Application No: EP/113/25/HH  
Site Address: 57 Manor Road East Preston BN16 1PY  
Description of works: Single storey side extension and other alterations.

This council's Planning & Licensing Committee considered this application at its meeting on Monday, 15th December.

Elevations as existing sh 2

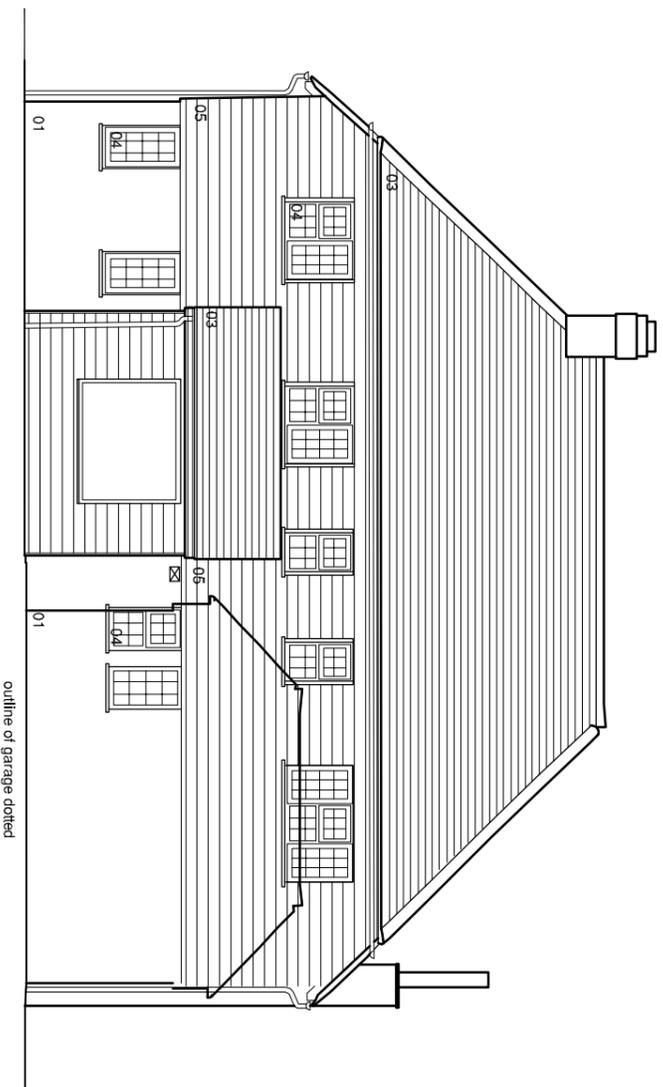
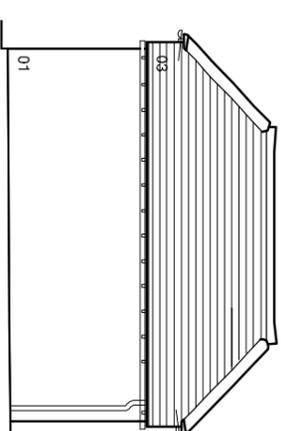
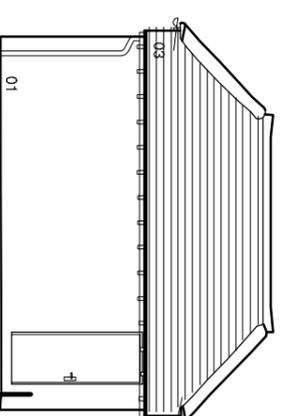
However, the committee also agreed unanimously to express concern the height of the garage is not explicitly shown on any of the drawings (that we could find). If possible, please could the agent be asked to provide this information on a drawing.
